File: SF19/67433  
Job ID No: DOC19/552422

**RE: Response to modification request for Bays 3-4a of the Locomotive Workshops (SSD 8517 MOD 3)**

9 July 2019

Drawing Title PROPOSED PLAN - GROUND FLOOR		
Project No. 16-002	Drawing No. SA-AR-DWG-BB-B4-0330	Rev T

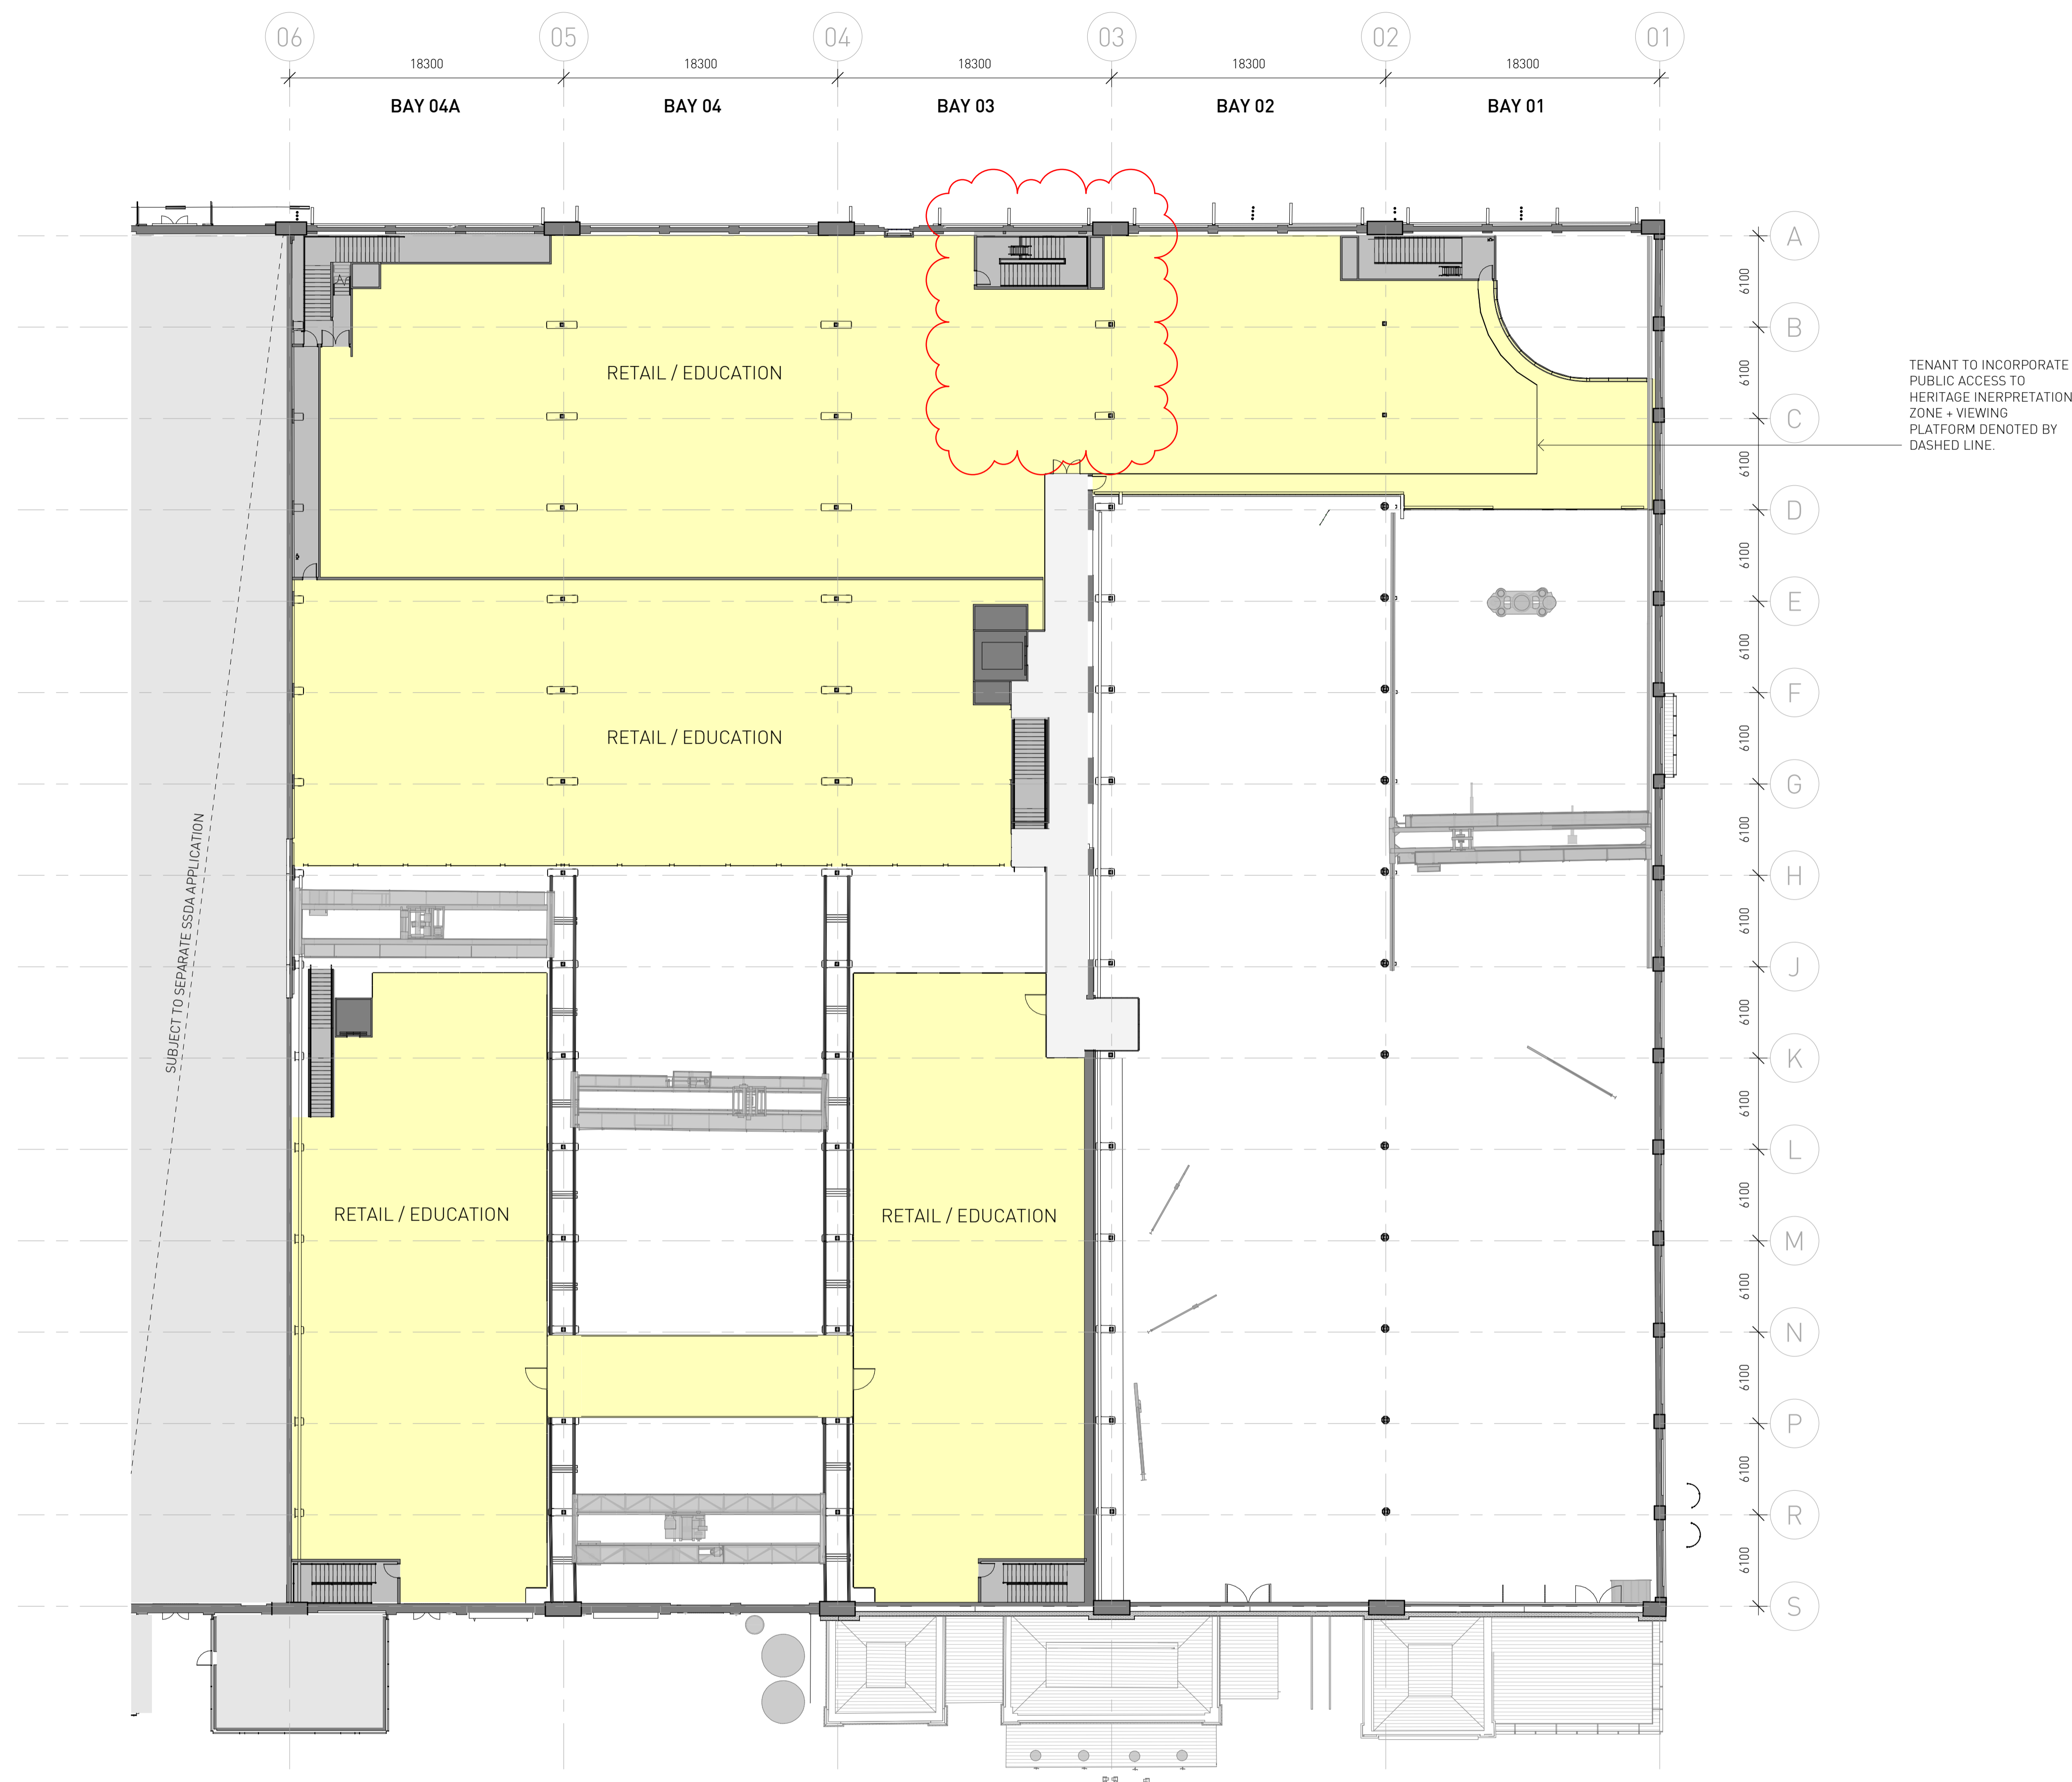
Following a review of the documentation provided, the proposed modification to the internal amenities' layout in Bay 4a is considered relatively minor and will not substantially alter the approved design. Therefore, I have no objections to the proposed modifications.

The new location of the plant room and provision of storage rooms adjacent to the approved goods lift in Bay 3 will increase the bulk in this area. However, it is acknowledged that there is a need for additional storage for the retail tenancies and the proposed position, adjacent to the loading dock, is the most sensible location for these service rooms. The rooms also align with the back-of-house areas of the supermarket tenancy and will not obstruct views to the significant perimeter walls and the architectural features of the Bay. Therefore, the proposed modifications to Bay 3 are considered acceptable.
